From: Amanda Scholes on behalf of Planning.Responses
Sent: 02 July 2020 07:33
To: Planning Scanning
Subject: FW: Planning Consultation on M/28/20/DOC

Engineers comments;

The level of detail supplied is currently insufficient to enable the discharge of conditions 11, 13 or 14.

402.06594.00008.07 Drainage Details MASTER 2007.XX.dwg

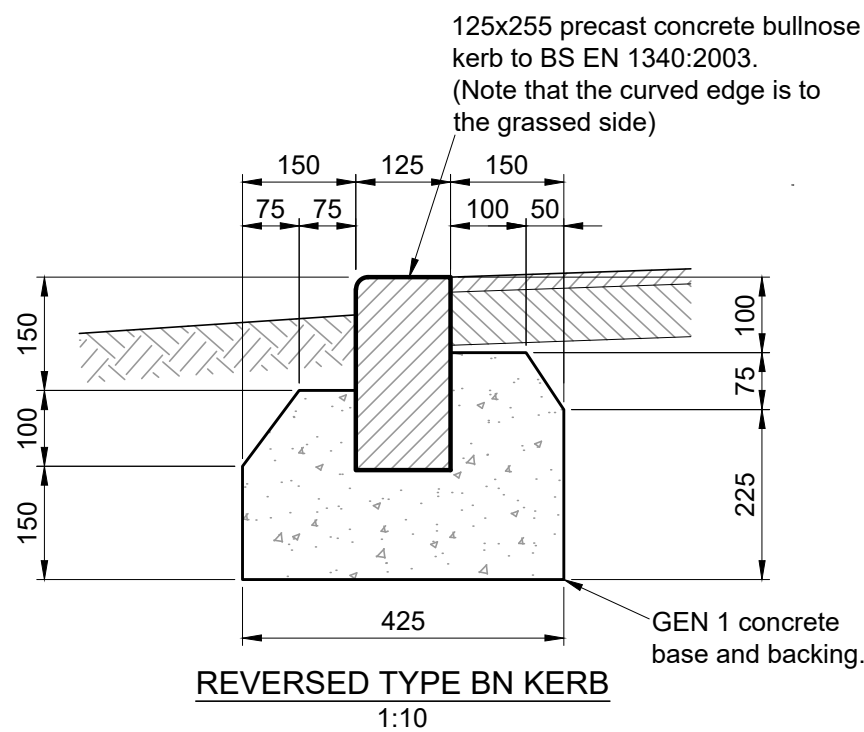
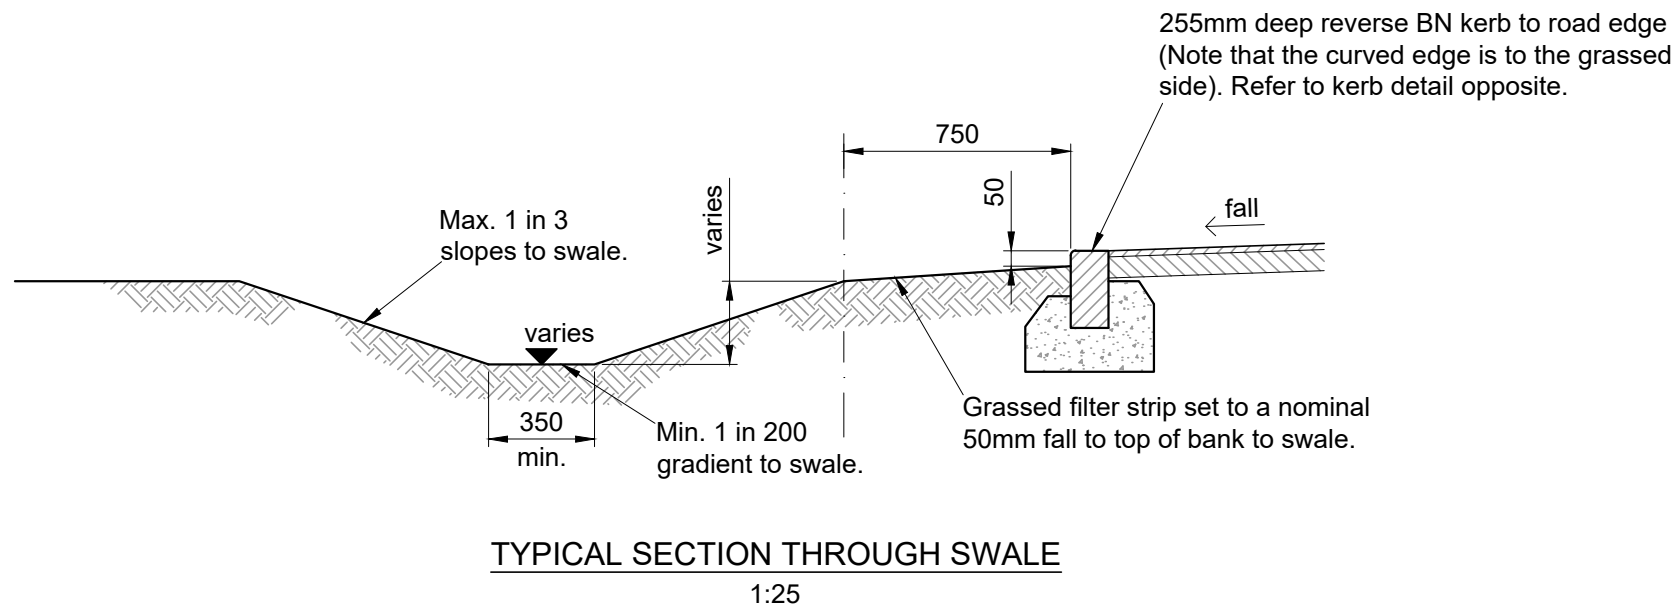
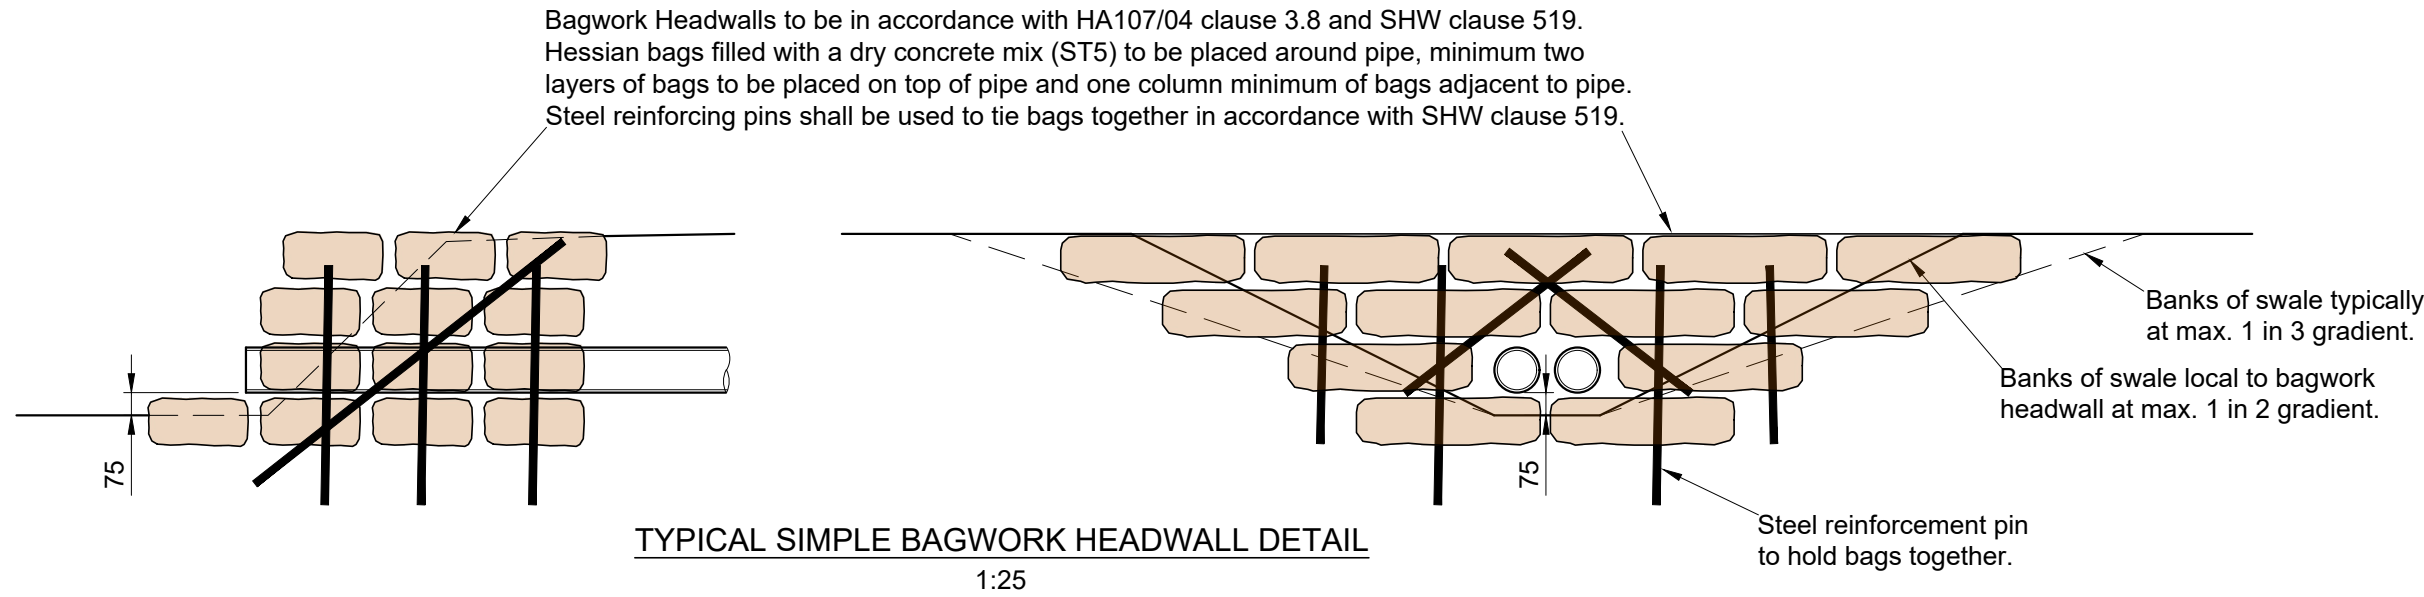
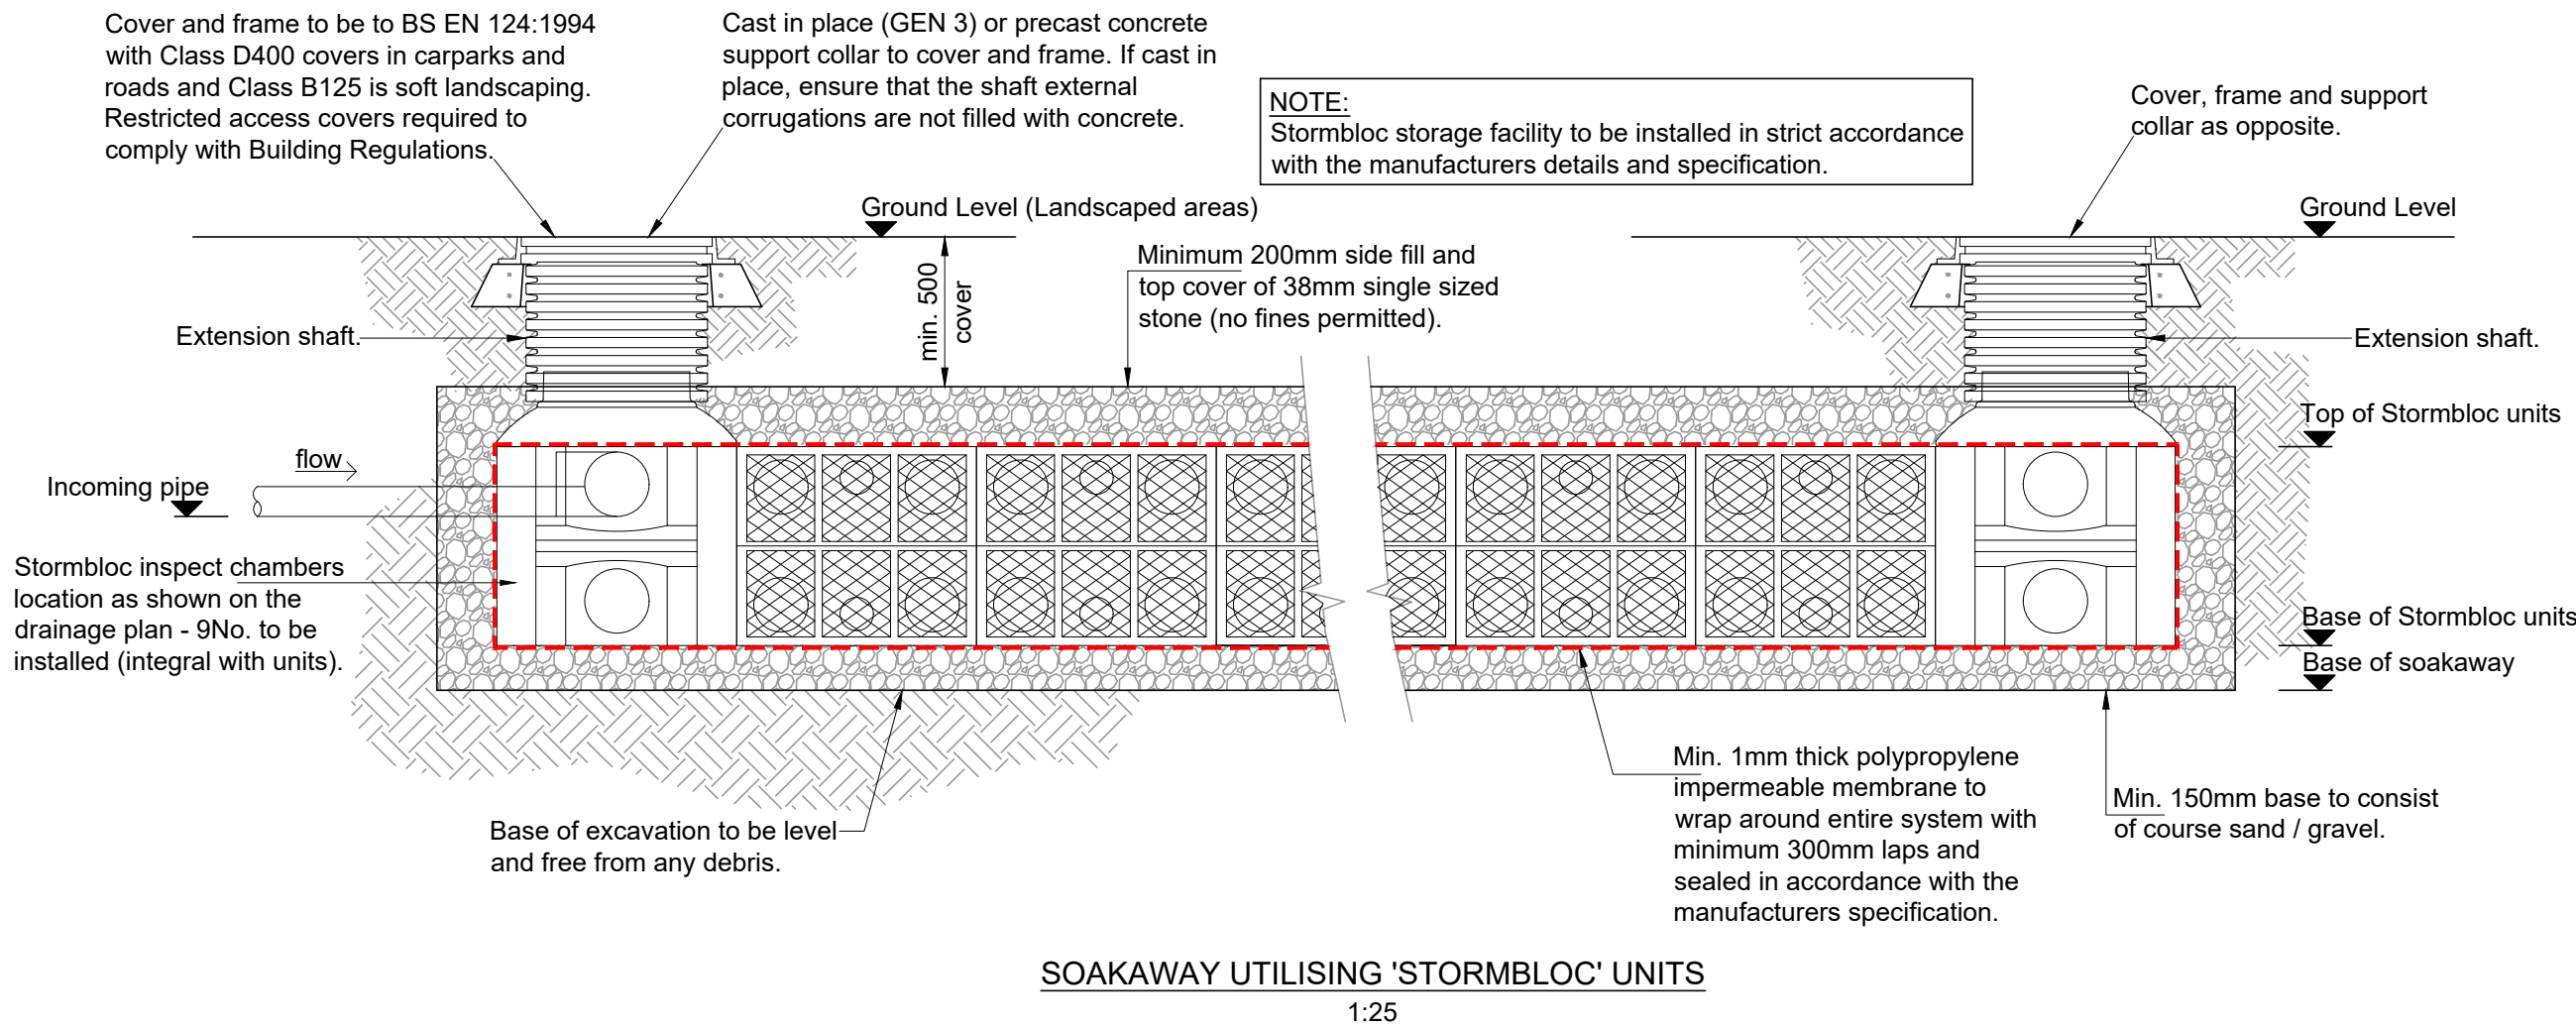
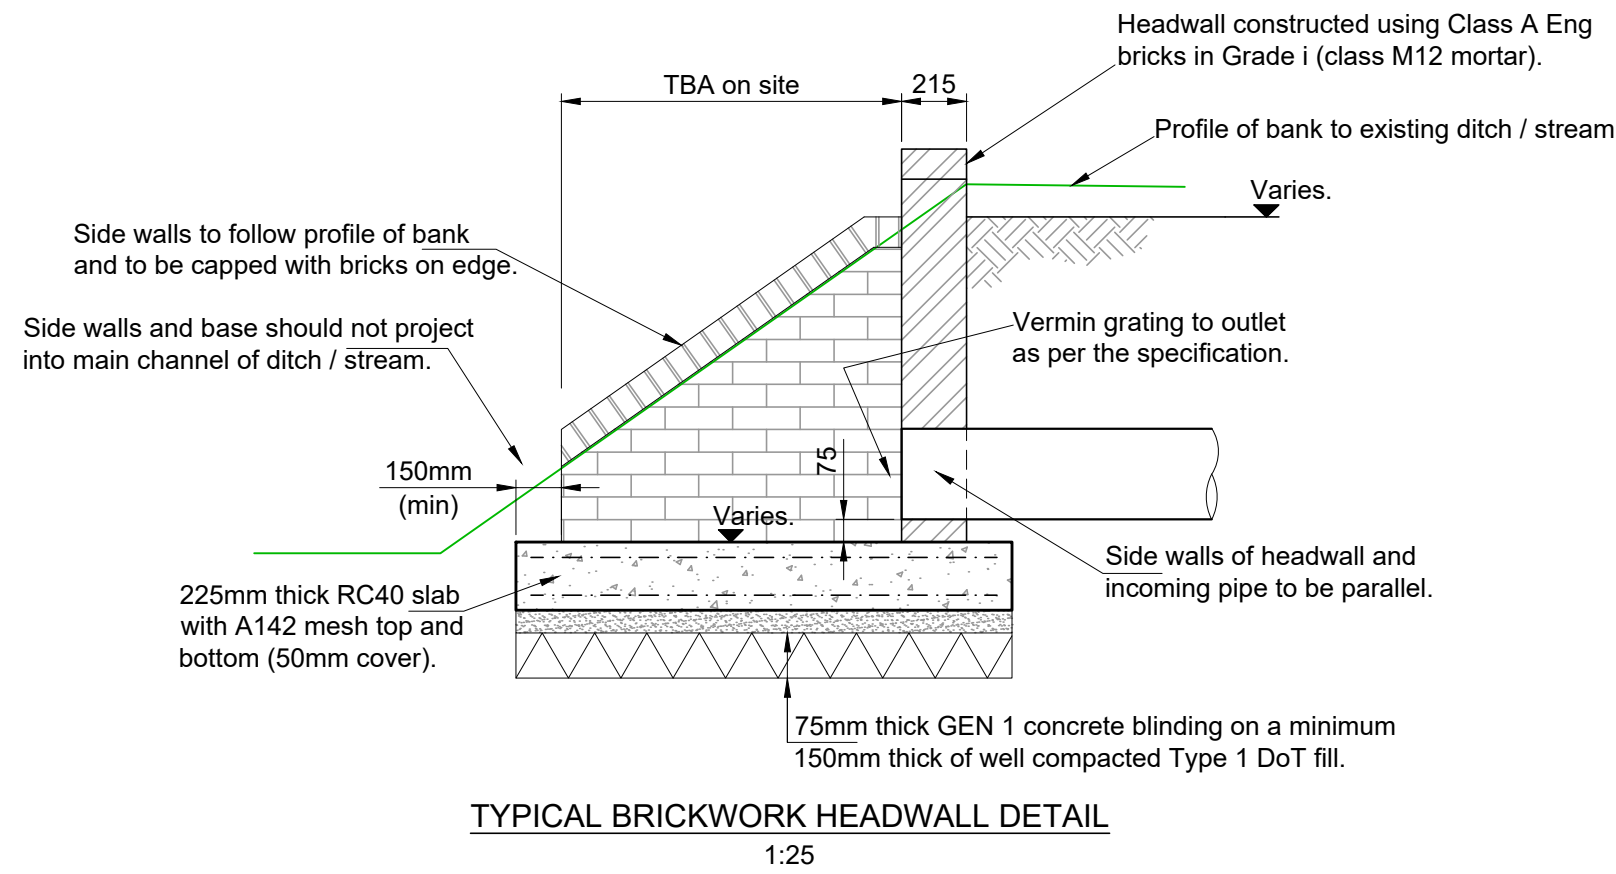
Once we have agreed the scheme principles, fully detailed plans will be required to include pipe/structure, cover levels/invert levels/base levels/diameters/gradients, etc, along with fully detailed construction drawings for all drainage elements. Please note that open suds features should be employed where possible. The current arrangement of crates is currently not desirable, since they have been arranged in manner as to use almost every piece of available space outside the root protection zones (zones will need to be confirmed), rather than achieve a more practical layout whereby membranes can be wrapped around the crates in a more suitable manner ie. reduce the number of corners. Please note that our tree officer will need to be involved in discussions in this respect due to protect the trees and the crates. Permeable paving will need to be employed where ever possible.
